**Consultation Response from Emma Mills
 KC Landscape**

Application No:	2021/94280
Proposed Development:	Erection of 67 dwellings with associated works
Location:	land at, Lady Ann Road, Soothill, Batley, WF17 0PY
Applicant/Agent:	Self Architects
Planning Officer	Nick Hirst
Date Responded:	16.12.21
Responding Officer:	EM
Responding Ref:	KK139

1. Precedent planting
2. Native hedgerow
3. Wild flower meadow
4. Path with planting
5. & 6. Community orchard
7. Wild grasses
8. & 9. Street trees and front gardens

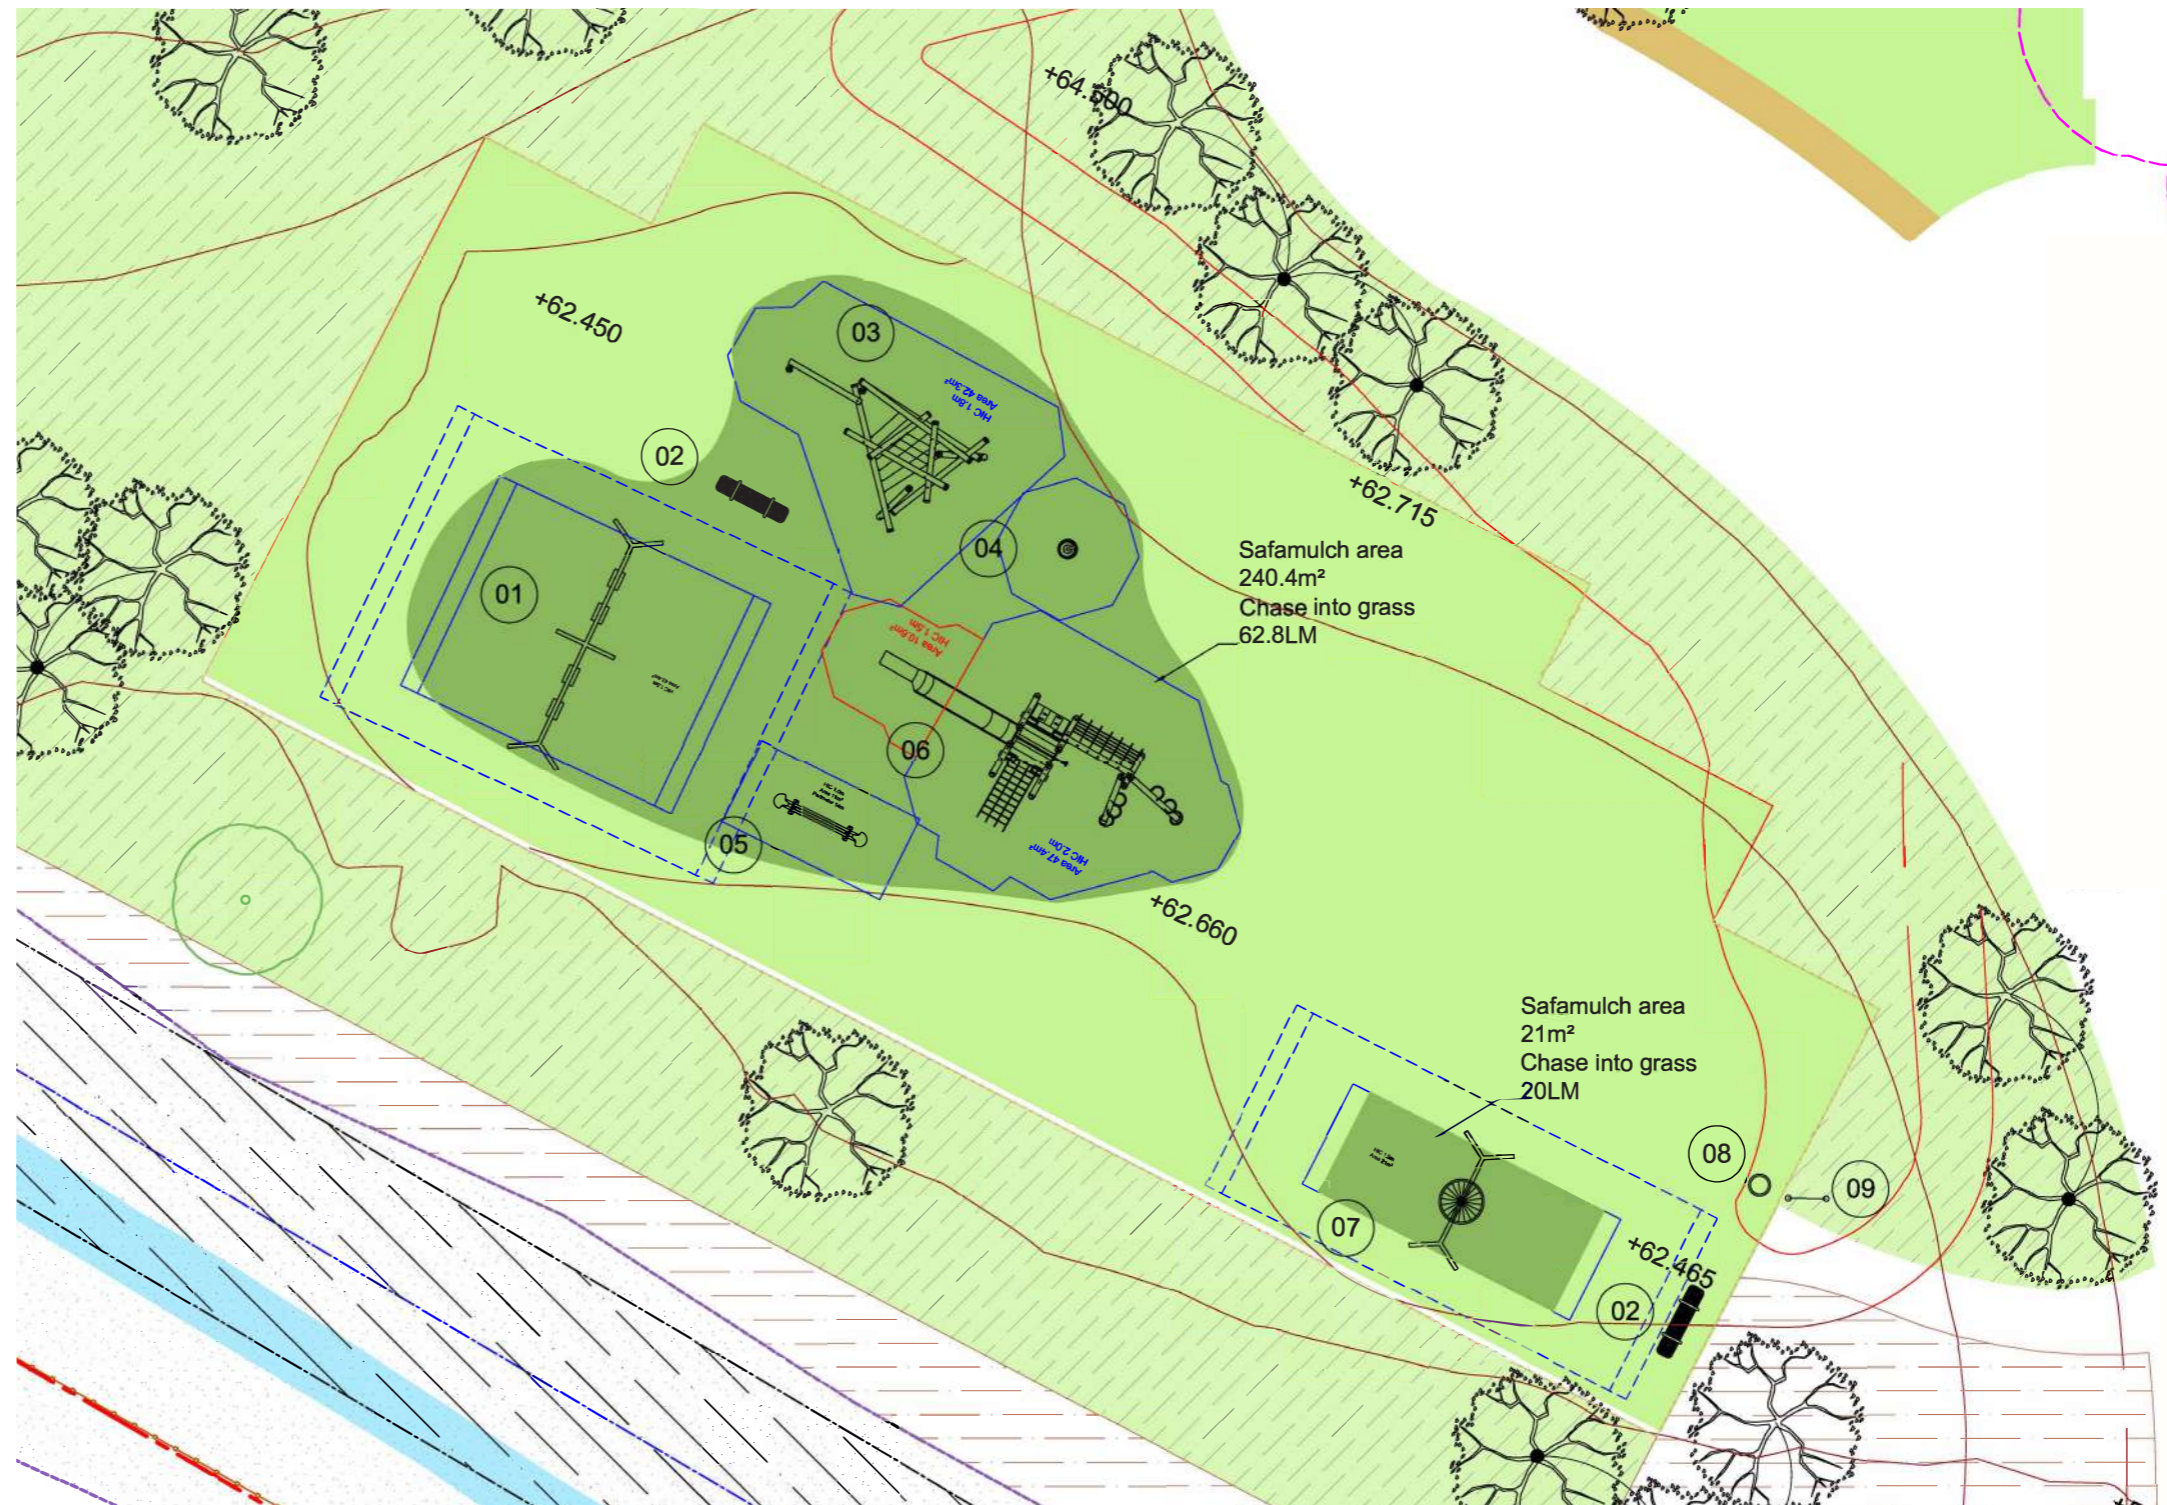
In this layout, the trees are in front gardens rather than street trees, possibly due to the constrained space, and whilst tree planting to the frontages are welcome, the number of trees indicated is inadequate and opportunities for trees in more front gardens are missed. Proposed tree species and size etc details will be required, also we presume there be root barriers given their proximity to the rear of the proposed pavements and driveways – full details will need to be provided prior to landscape scheme approval. We would not want the proposed tree removed to necessitate s38 road adoption further down the line.

Hedgerows are welcomed to break up the dominance of hard surfaces/car parking to frontages, species and planting density details will be required.

The landscaping proposals submitted along with the planning application, are welcomed however, further clarification on proposed species & mixes for elements such as native shrub mix, native & formal hedgerows and trees are requested. In addition, details of the “wildflower meadow on regraded embankments” should also be detailed within the proposed soft landscape plans/specification.

Where the inclusion of community facilities on site, careful consideration needs to be given to safety and security issues. The location at the entrance of the site is inviting and visible, however, the landscaping scheme dwgs no. GA 001-003 inclusive, dated 17.11.20, include a proposed native shrub mix along the entrance road and adjacent to the proposed pathway down to the POS, the equipped play area and community growing area.

This may impede natural surveillance and may be better substituted with long flowering lower groundcover, preference for native and proven beneficial to pollinators where possible for this location adjacent to the Howley Beck. Where possible species included in the Plantlife list of species to avoid should not be included on the plan schedule.

## Equipment List

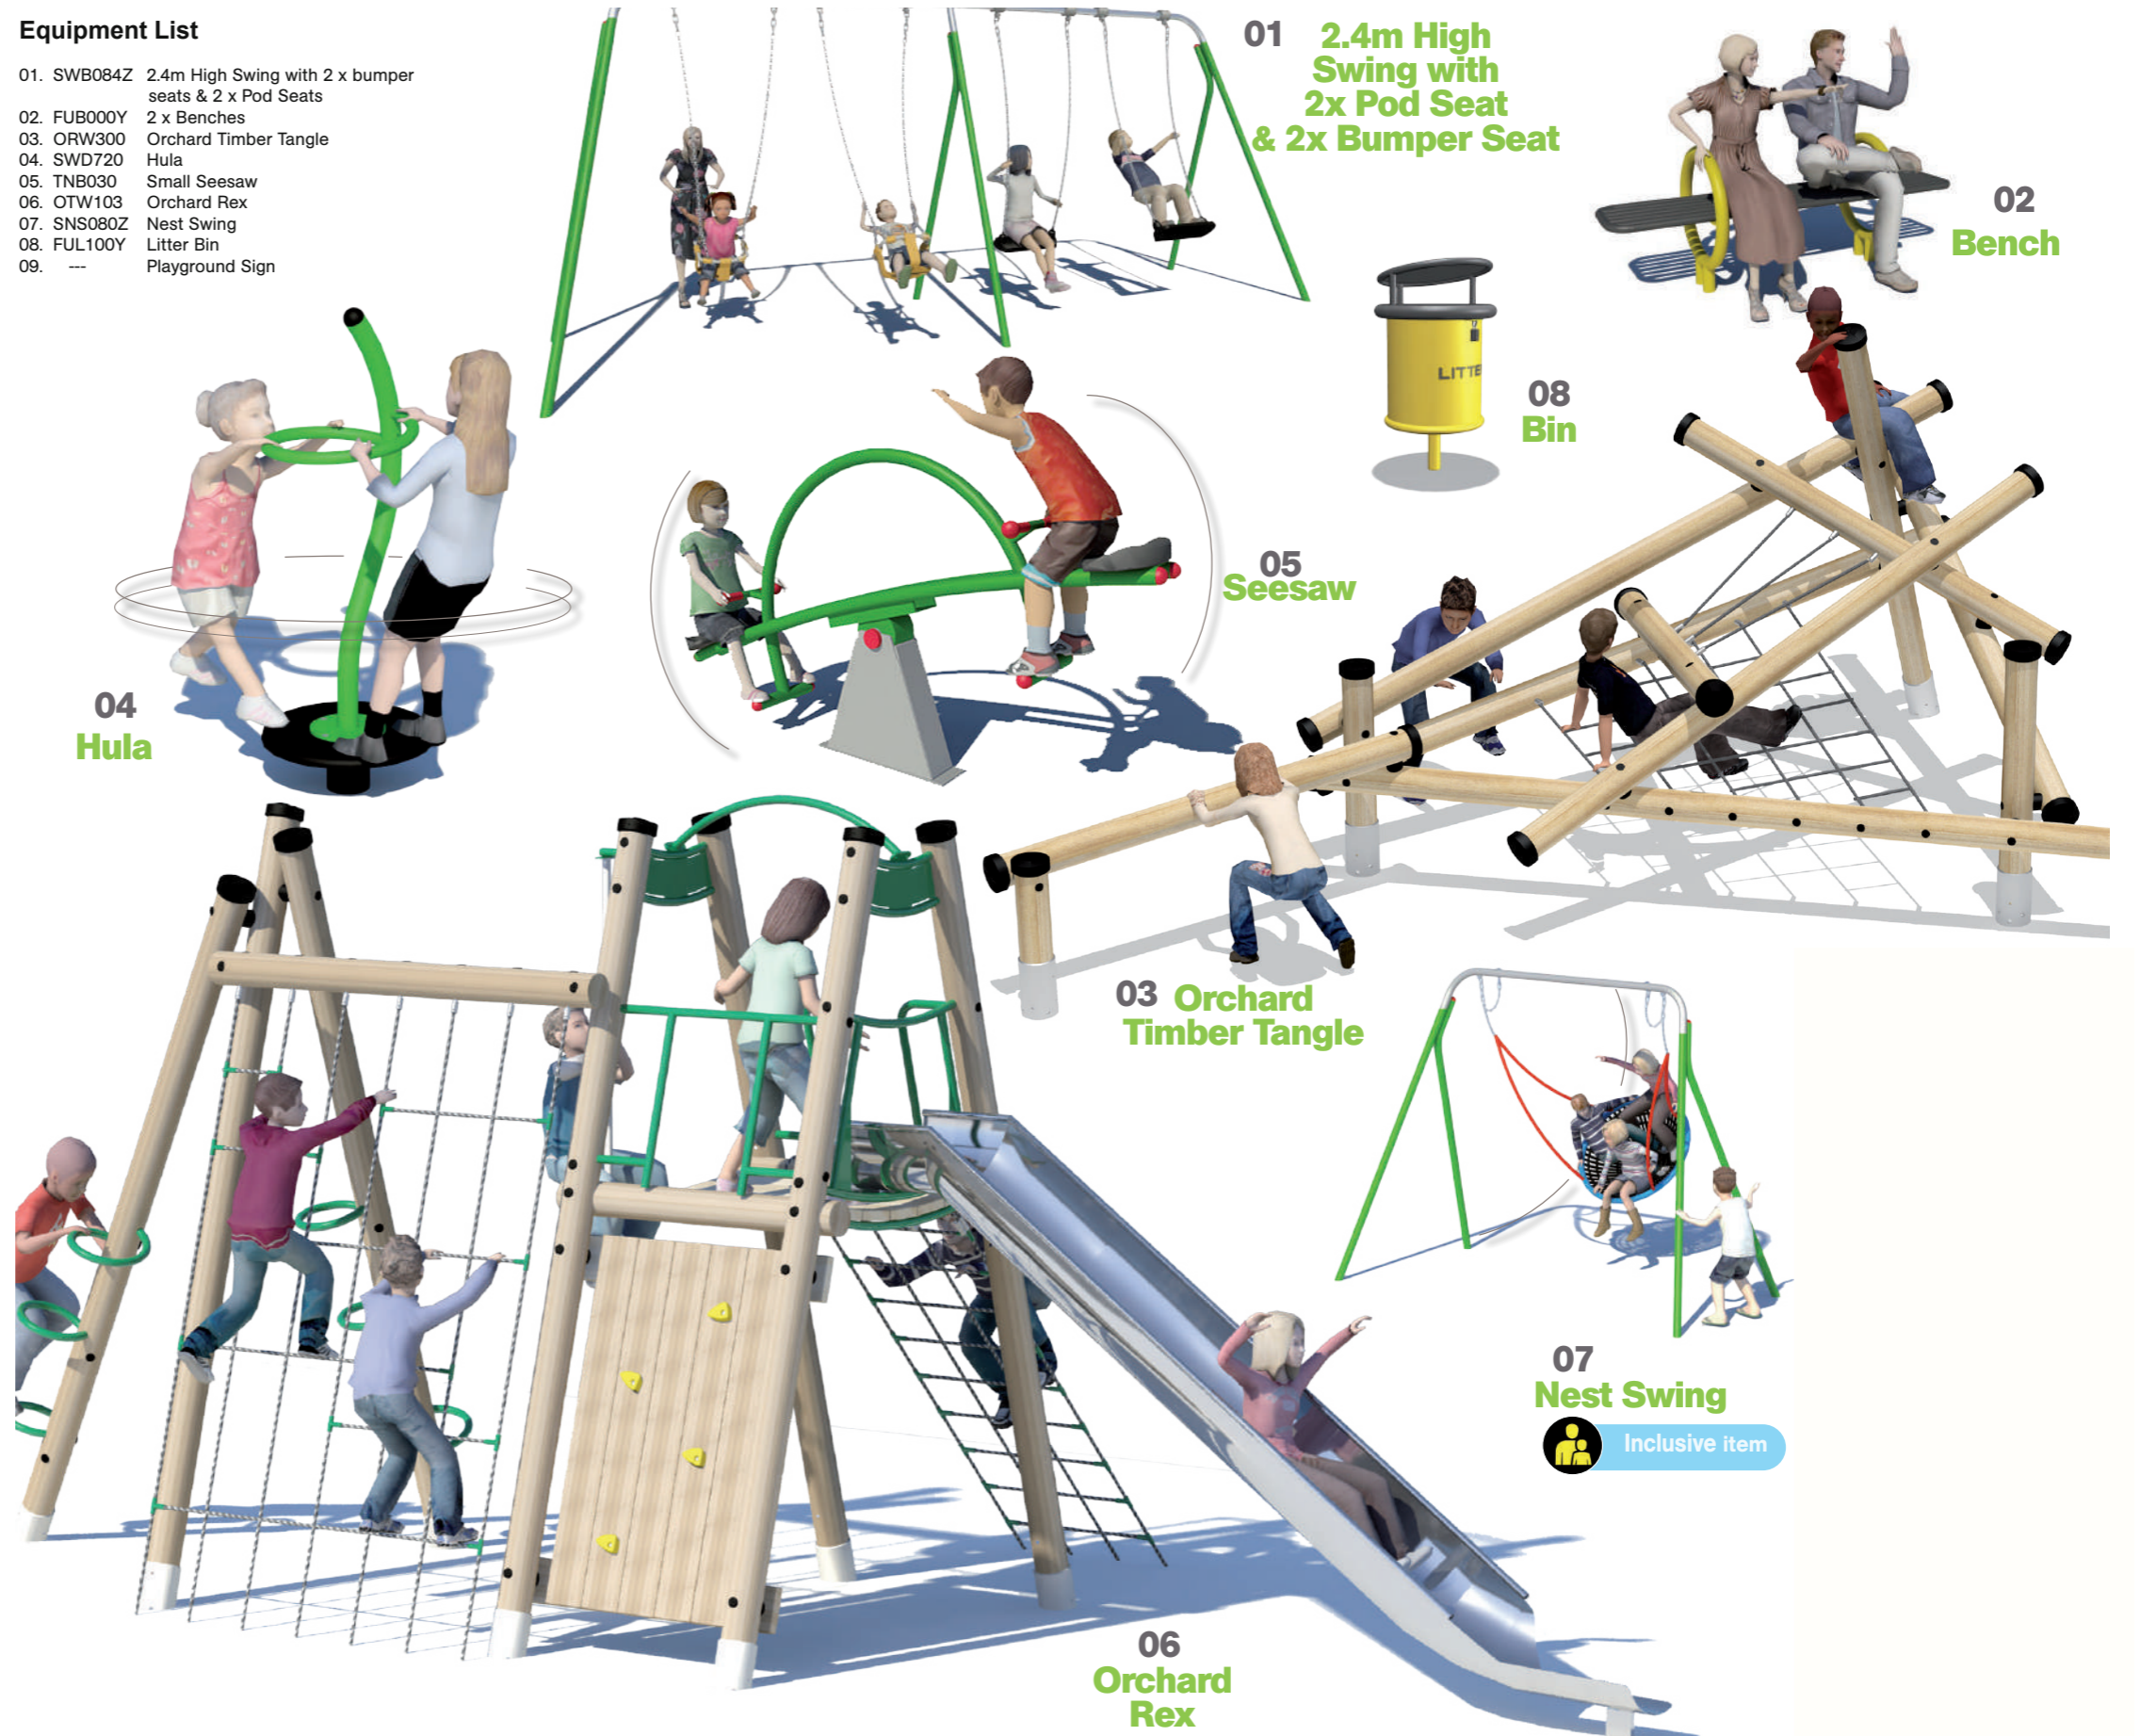
1. is it possible to install this play area OVER the attenuation tank as some of the footings for the play items require large concrete foundations?
2. Will there be inspection covers protruding through the safety surfacing?
3. Will it be fully meet BS EN 1176 & 1177 over an attenuation tank?

Play area layout – not sure this is the final design or indicative. A couple of queries about siting and location of proposed benches and equipment, this bench is in potentially blocking half of the access path.

Bark is shown as the safety surface – has DDA accessibility been considered? Bark is difficult to push wheelchairs and push chairs across, some more accessible areas would be beneficial to encouraging use by all abilities. There is a potential for this play area, with its play bark surface, to suffer in terms of useability due to potential poor drainage or becoming waterlogged in extreme wet weather being located adjacent to the Beck. Wear pads will be required under the swing, slide, see-saw, roundabout, etc.

Why is there such a large area of empty bark? Could this be a grassed informal kickabout area?

Good range of pieces of equipment included, compliments the offer in the vicinity, however, we would recommend this is metal play equipment in this location for durability (one of the pieces looks like a timber log stack climber with nets – is there a metal version?). Equipment appears congested in one area to the south – is there a reason for this?

No surfaced link path to the community growing area indicated – needs to be accessible as far a practicable for widest use by people of all abilities.

Slide ideally shouldn't be pointing S/SW due to heating up in the summer.

Natural playful elements such as boulders are welcomed, perhaps need connecting into the playable space and features a little? Used for linking other natural features or equipped play elements?
